RE: CAO15-001/VAR18-002 Request for Information (5637 E Mercer Way, King County tax parcel #1924059312)

subject Review of 5637 East Mercer Way (MI Treehouse, LLC) – Reasonable Use Exception and Variance Applications (CAO15-001 and VAR18-002)

Subject: Geotechnical Peer Review – CAO15-001  
5637 East Mercer Way  
Mercer Island, Washington

SITE PLAN
5637 MERCER WAY
MI TREEHOUSE, LLC
 11030 SE 30TH ST
 BELLEVUE, WA 98004

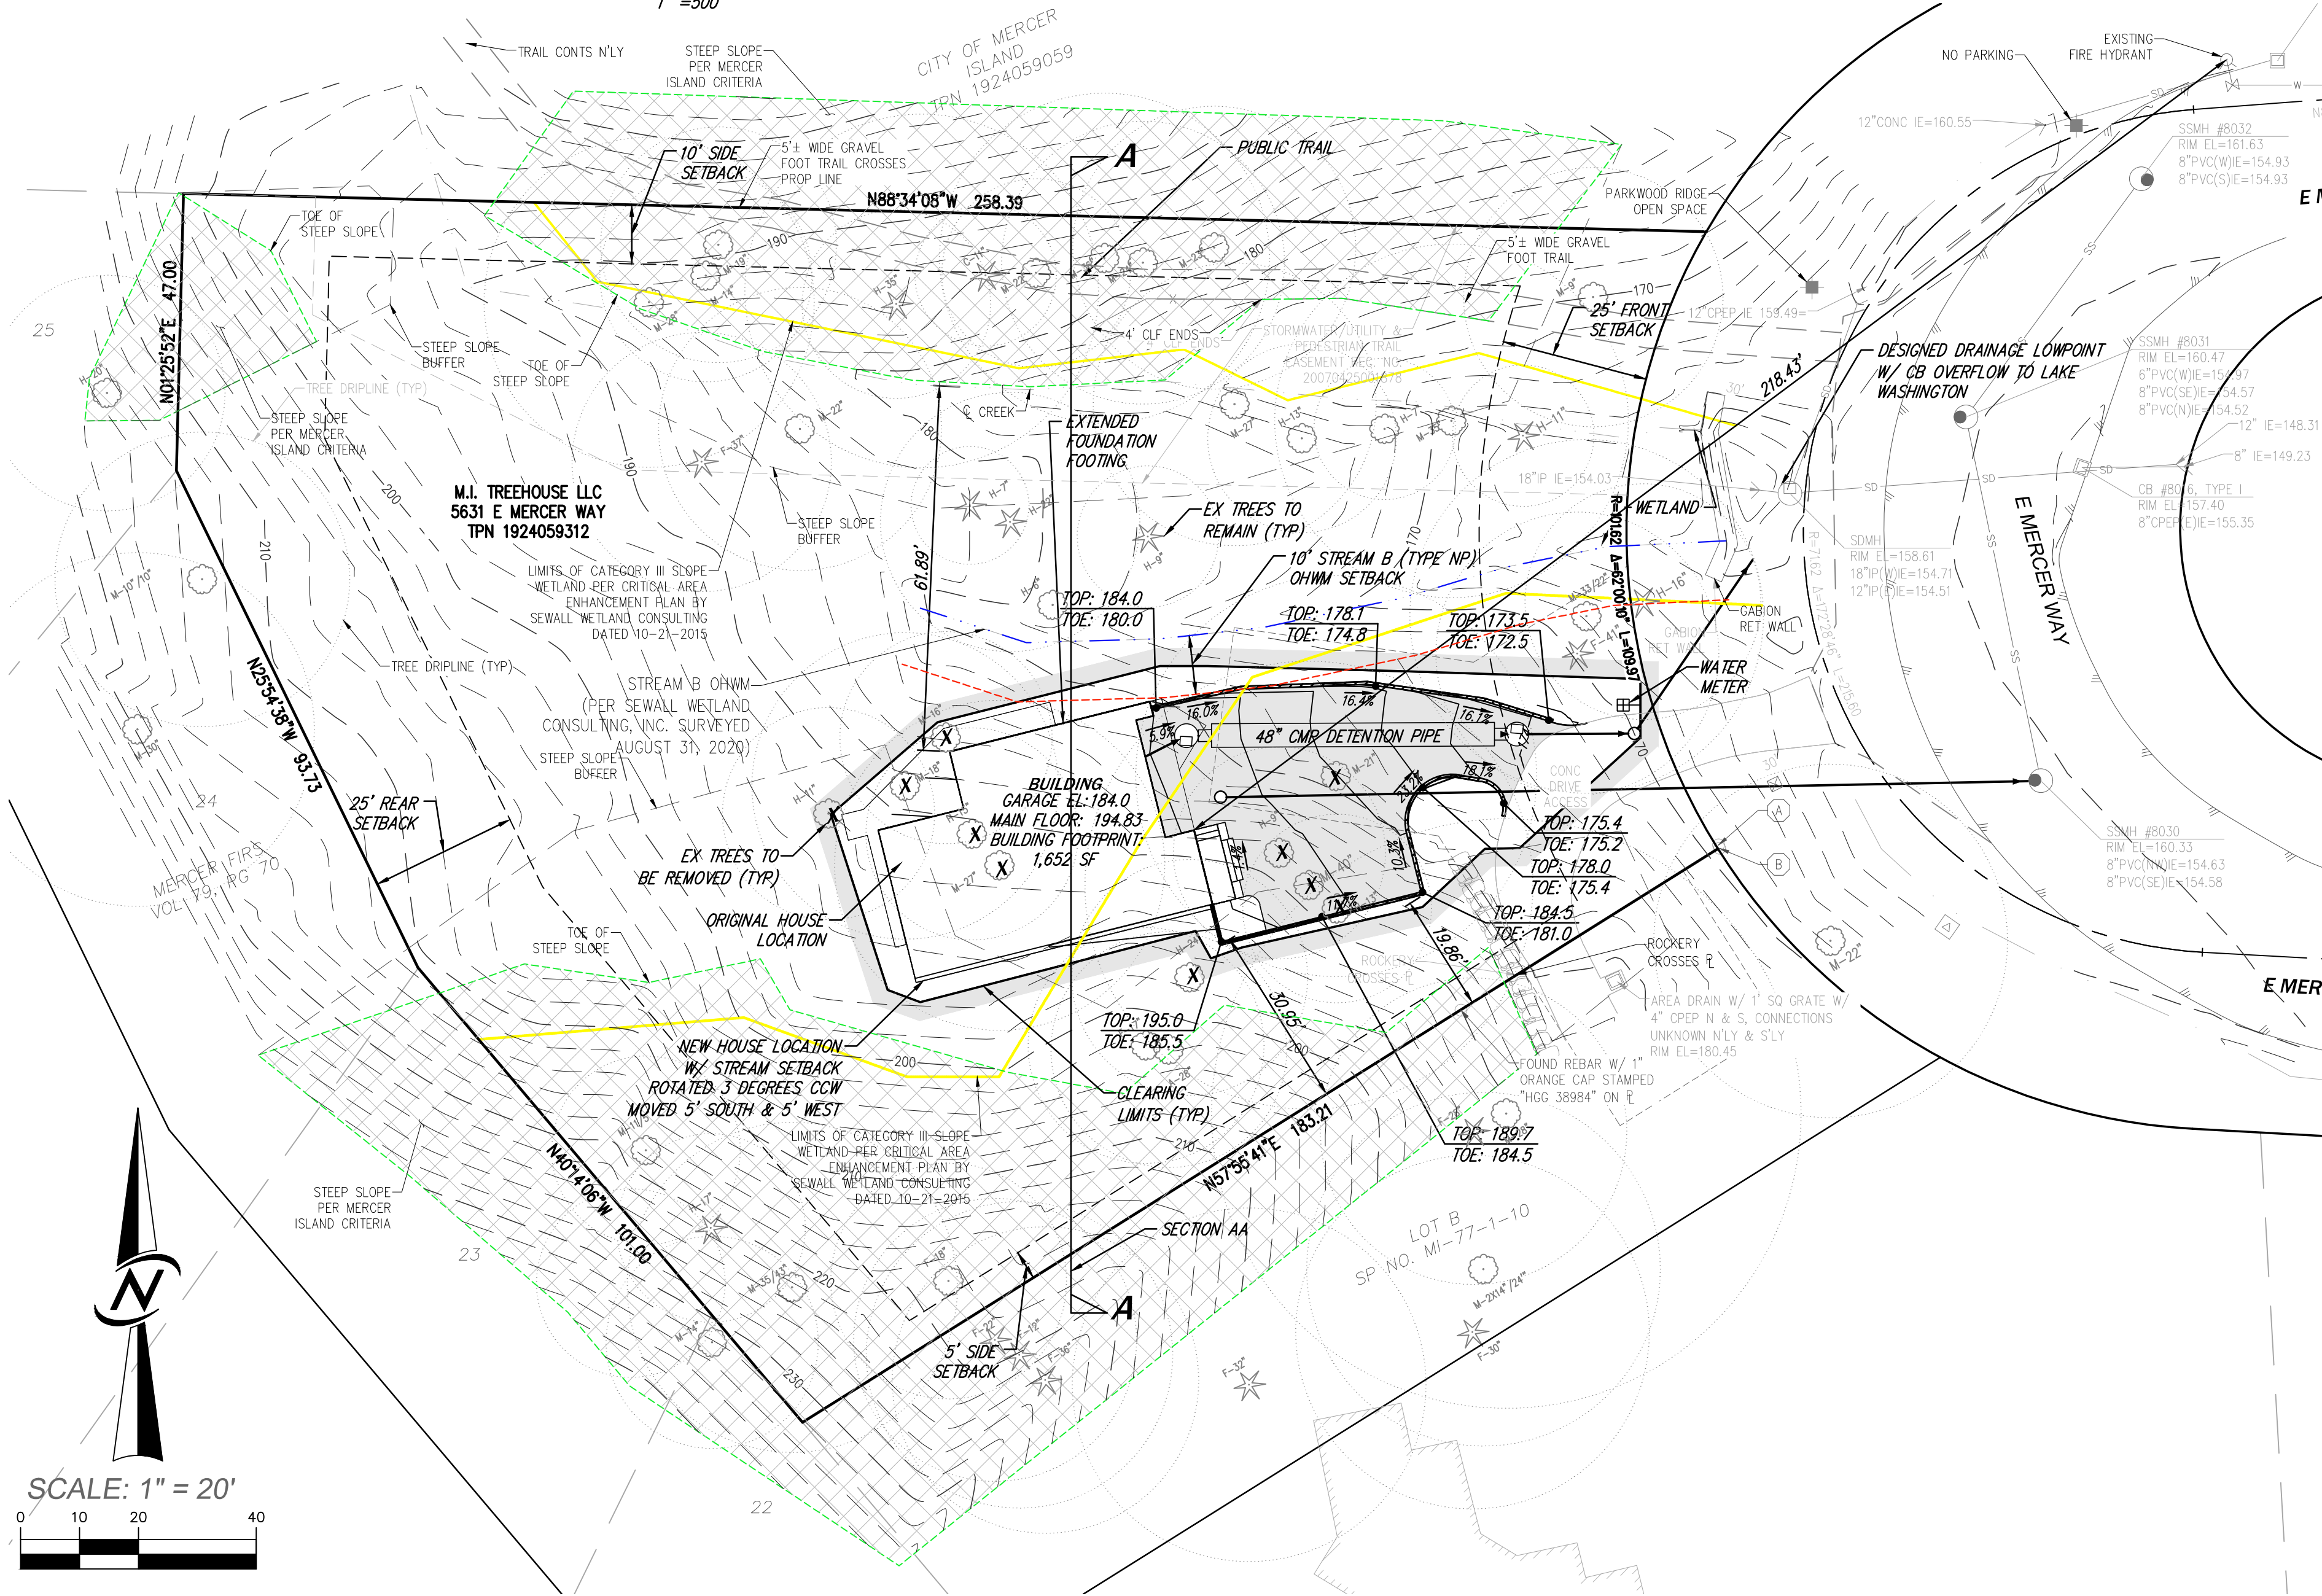
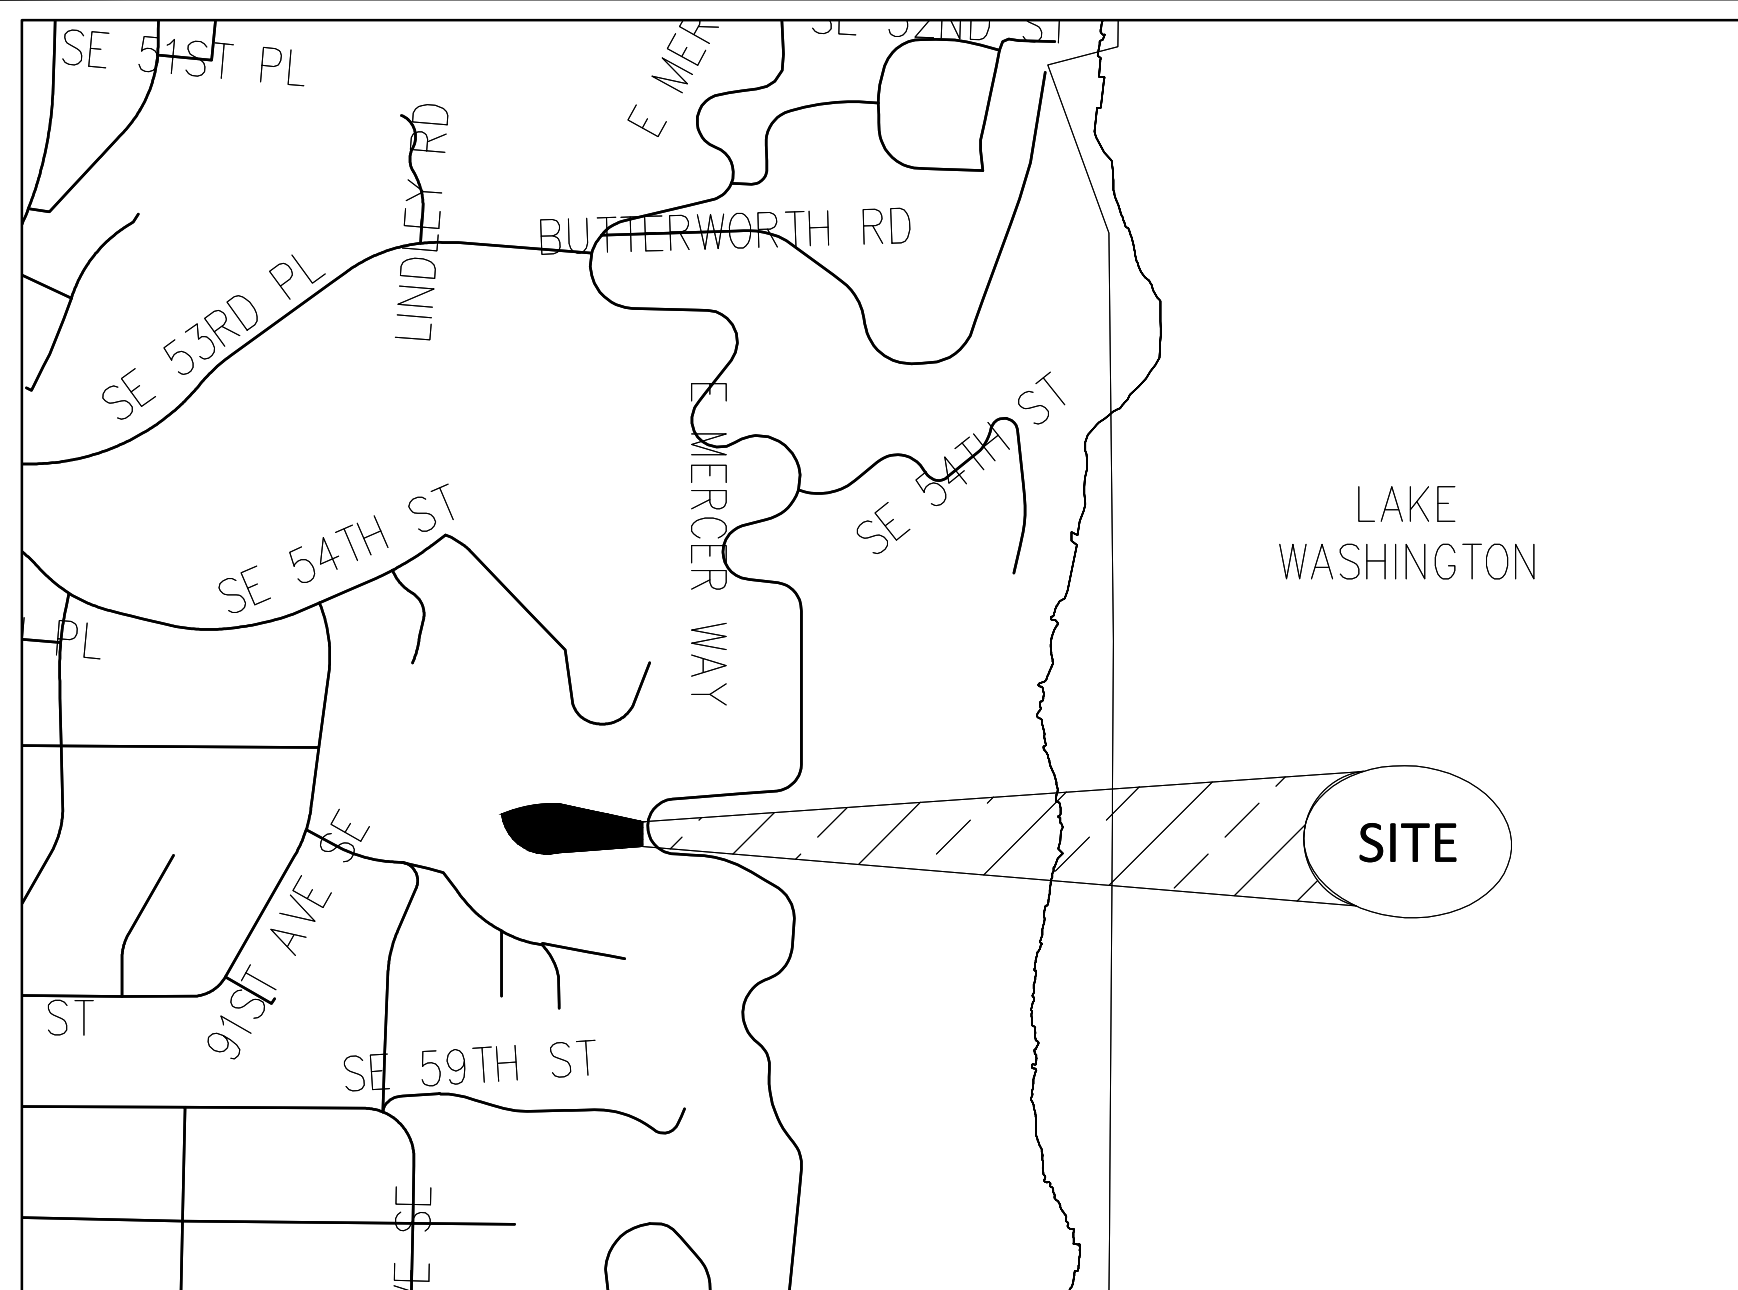
The revised site plan no longer depicts a retaining wall located west and southwest of the proposed residence. ESA previously commented on the wall and associated grading for the building foundation and potential impacts to wetland hydrology. **ESA seeks clarification for the current lack of grading within the slope wetland to accommodate the structure.** If grading is still required, ESA continues to recommend the applicant provide additional details about the onsite drainage system and how it will operate to not artificially drain wetland areas. Alternatively, the applicant can propose an offset from the drainage system that would account for lost wetland hydrology and mitigate impacts through additional credit purchase.
